POND 1  
FINAL ASBUILT  
FIELD DATA COMPLETED 5-17-23

POND 4  
FINAL ASBUILT  
FIELD DATA COMPLETED 5-17-23

POND 1 PLAN

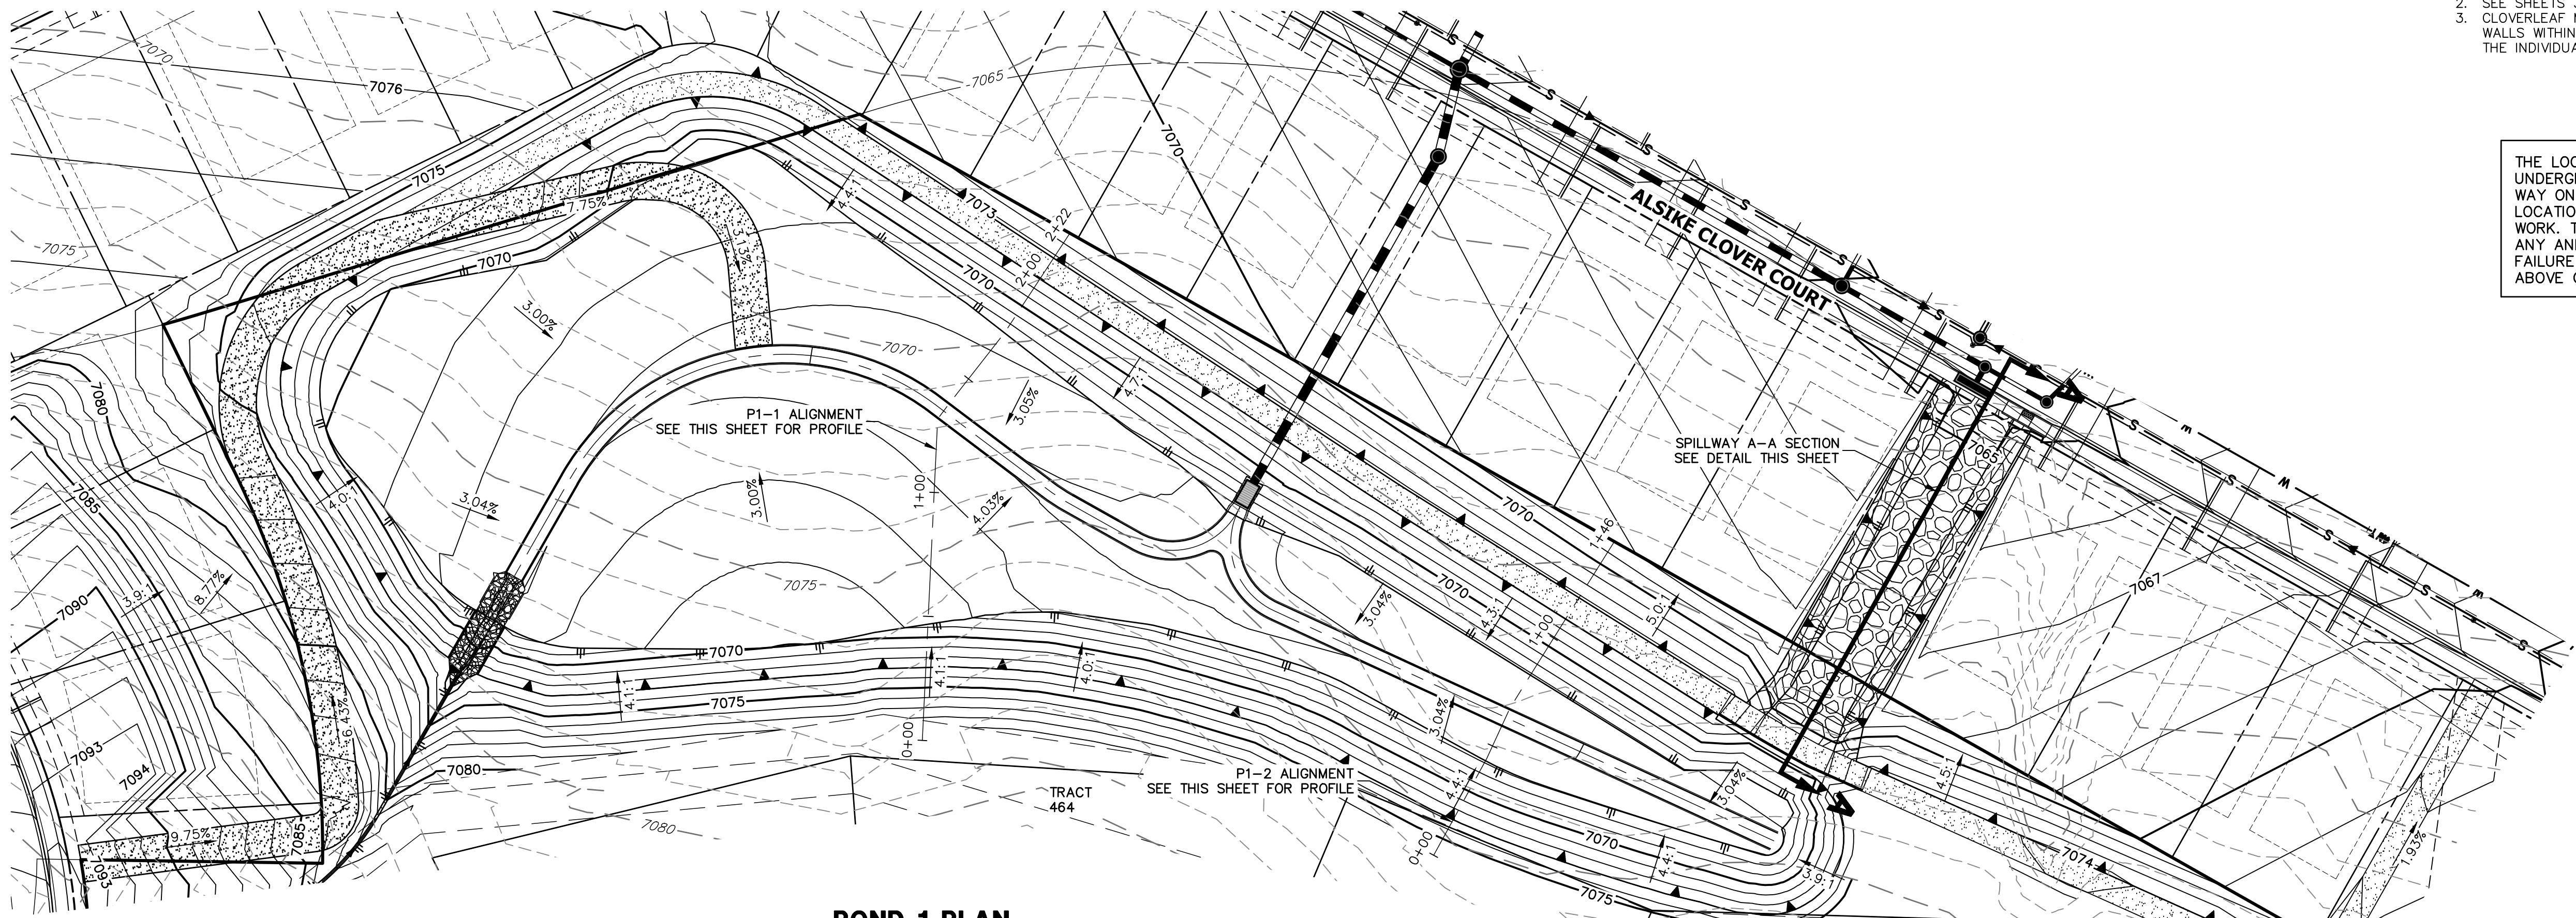
Per PA Punchlist:  
"Eastern side of spillway does not have a discernible embankment per plan. Supposed to be 4:1 slope for 1ft of elevation. Elevations of spillway crest or embankment likely not built per plan. Construct per plan."  
Or come up with a suitable alternative spillway design that is at an acceptable depth and properly armored.

Contractor has regraded this area, and an updated as-built topo file has been provided showing the spillway was built per plan.

POND 4 - PLAN

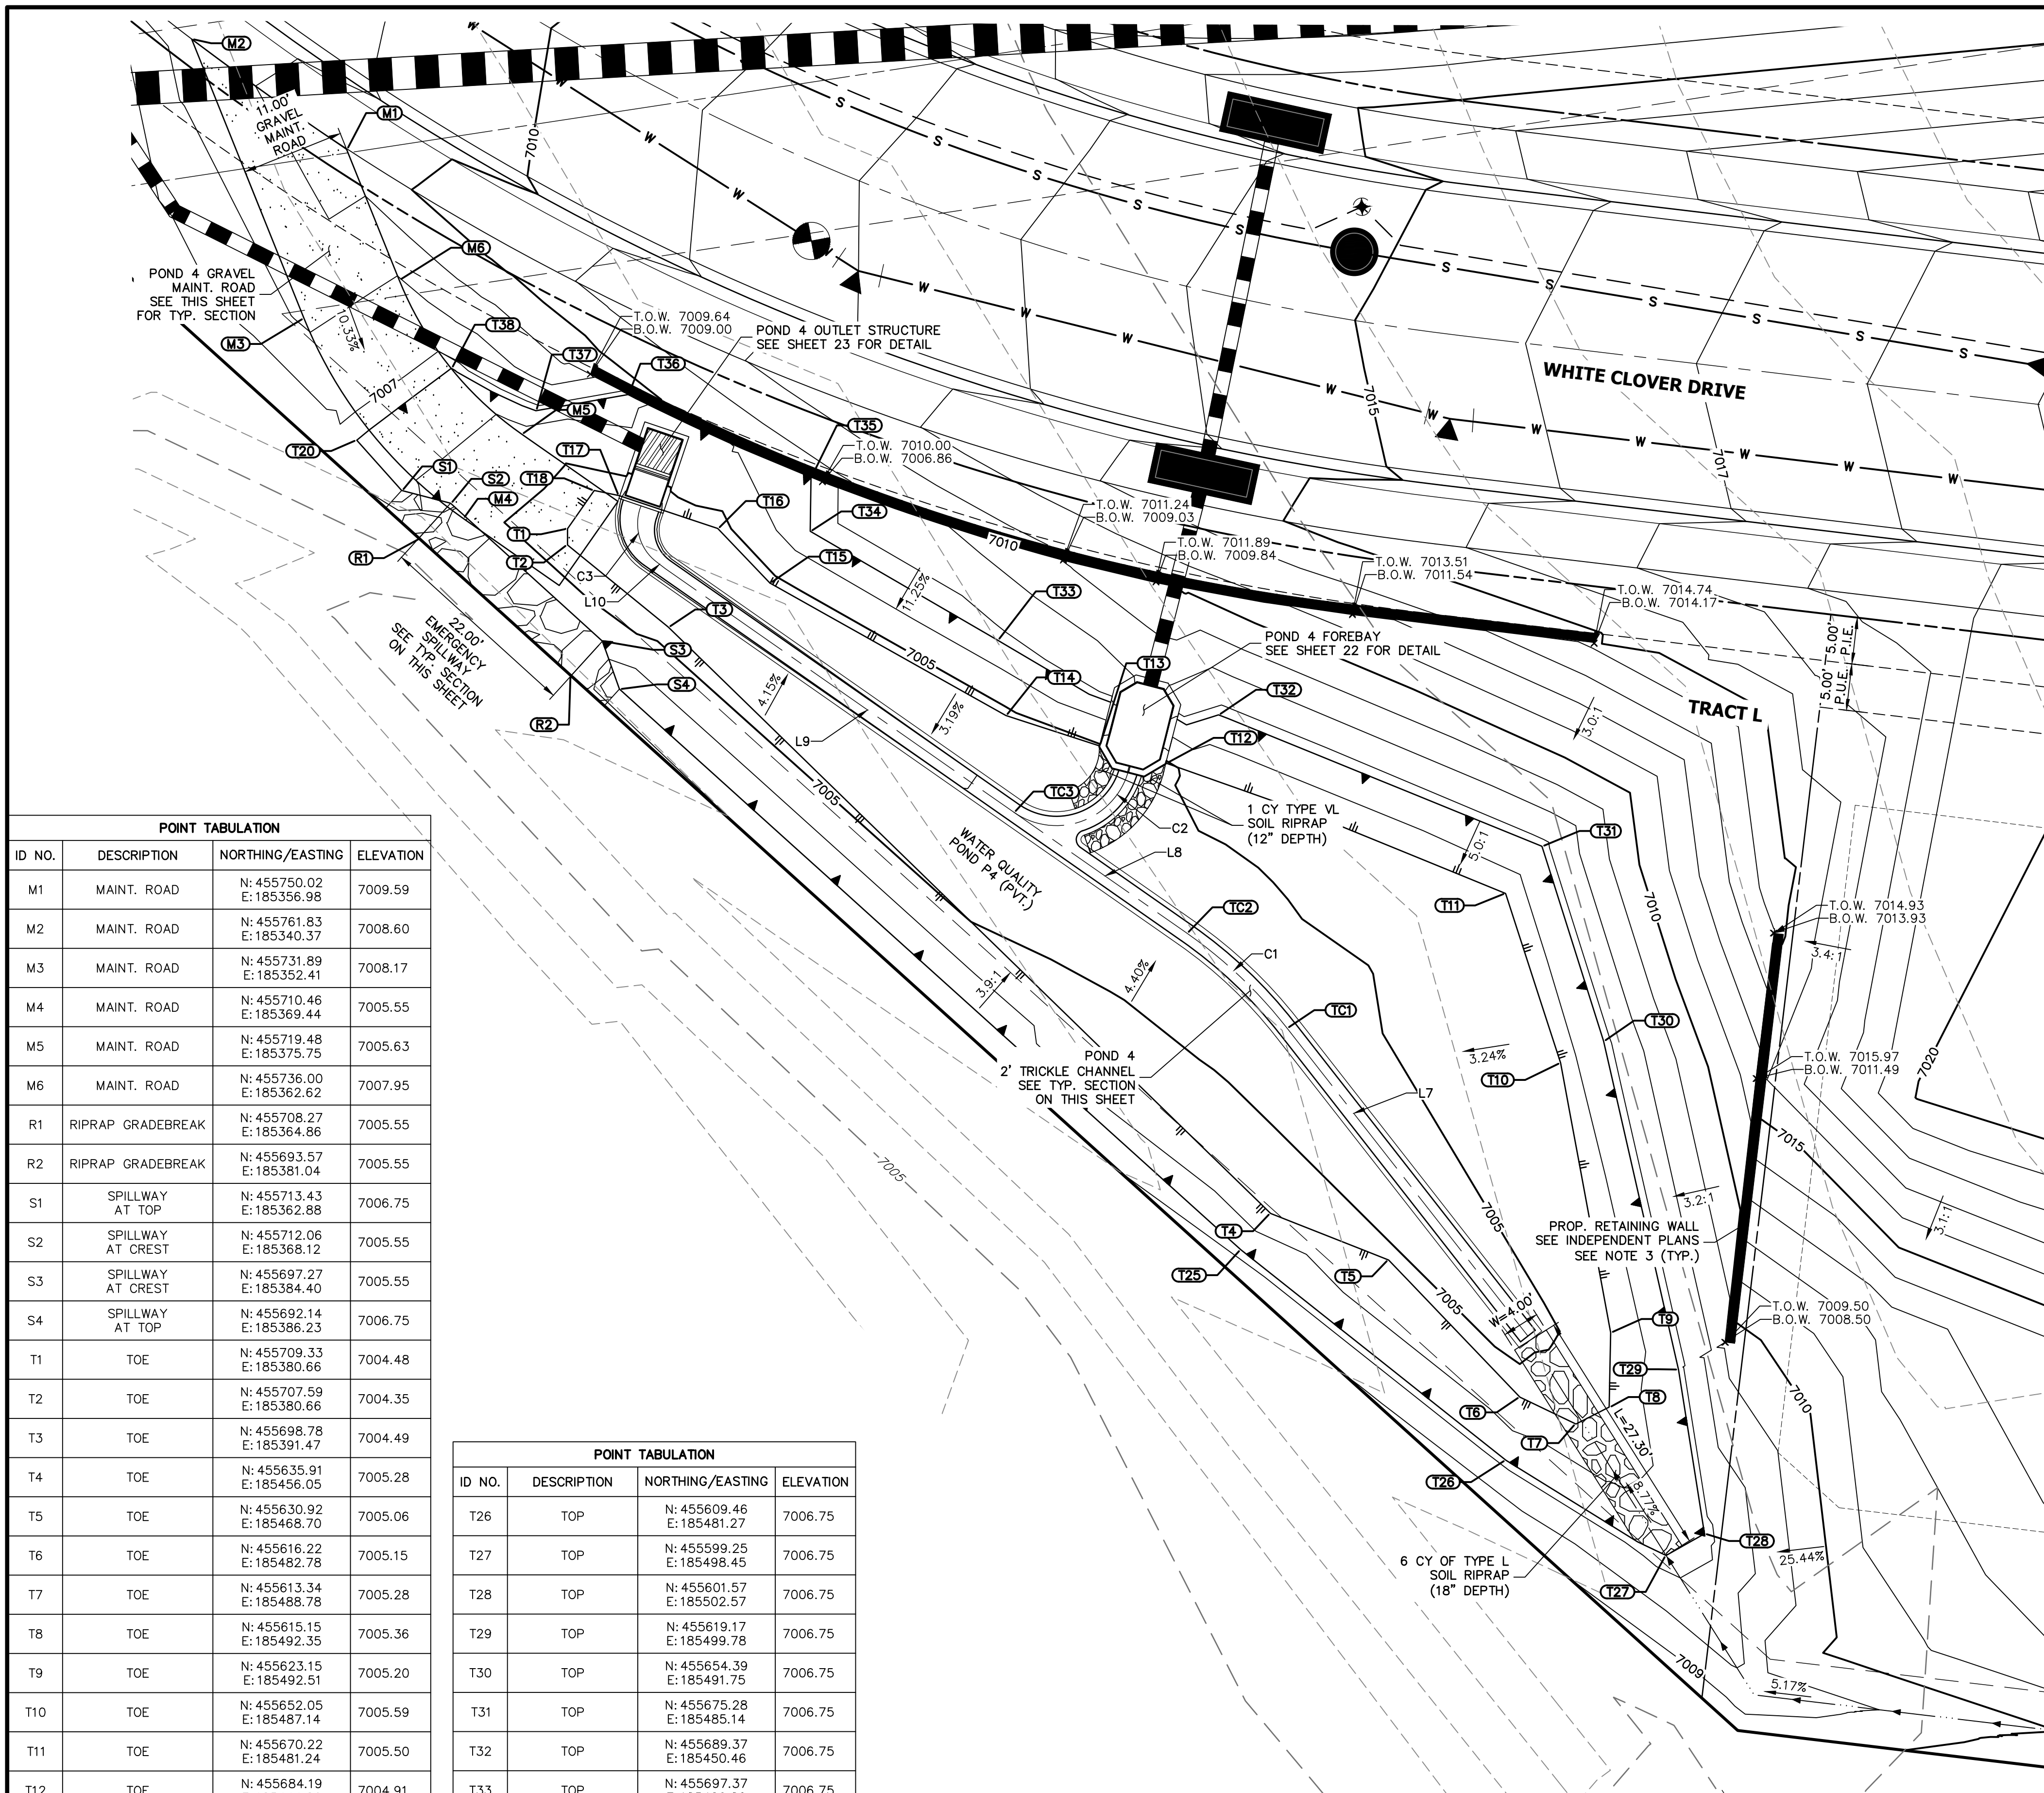
Per PA punchlist:  
"Check elevations of spillway crest and pond embankment. Does not appear to be a 1ft difference from spillway crest to top of pond embankments."

Updated as-built topo provided showing more than a foot between top of pond and spillway crest after contractor regraded this area to plan.
